Sussex Police
Serving Sussex

Your Ref: A/11/17/OUT

Date: 14th February 2017

Re: Land South of New Road A259 & East of Brook Lane, Angmering, West Sussex.

SITE PLAN, 1:500@A1, 1:1000@A3

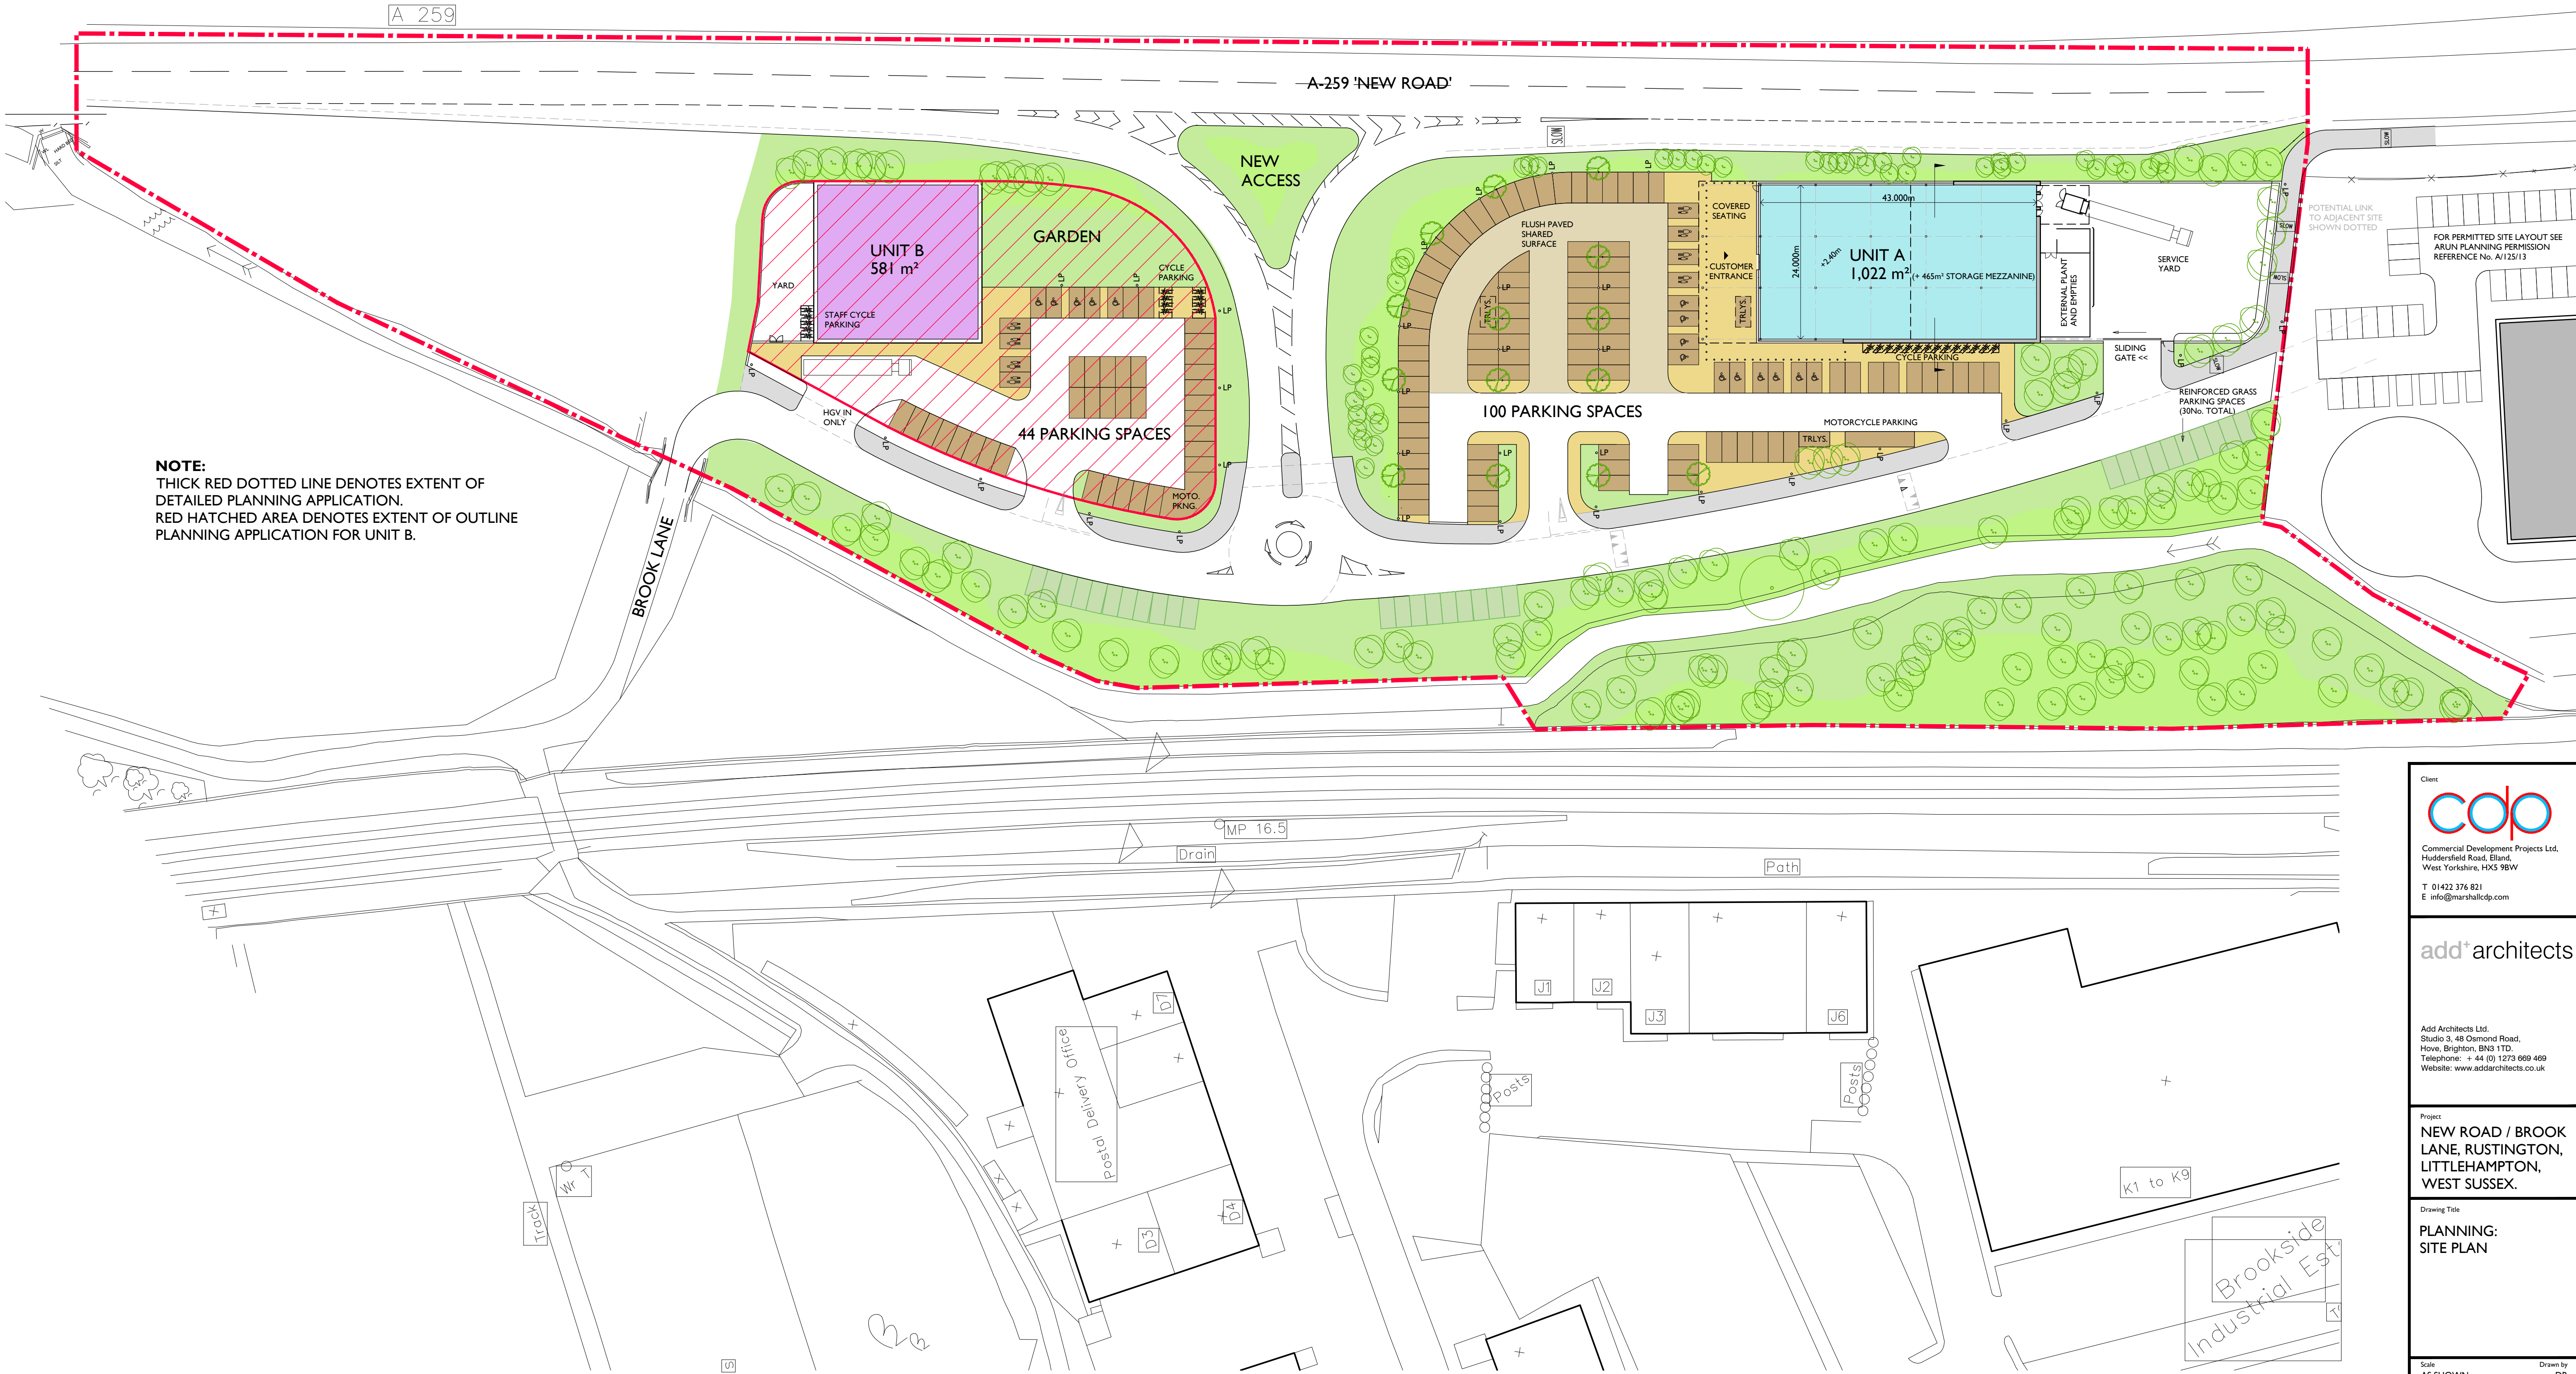
I recommend that the vehicle delivery area is segregated. At present the site plan shows Unit B delivery vehicles manoeuvring within the customer parking bays. I have concerns that this design has the potential to cause collisions with persons and vehicles endangering the safety of the users of the car park.

Appropriate fit for purpose ground anchors to physically secure the motor cycles should be incorporated within the proposed motorcycle parks. Cycle securing stores should have a design of cycle stand that encourages the locking of both wheels and frame to a secure point. I recommend that the proposed cycle store for Unit B is moved to a position closer to the entrance. This will take advantage of the natural surveillance provide by the frequency of customer movements.
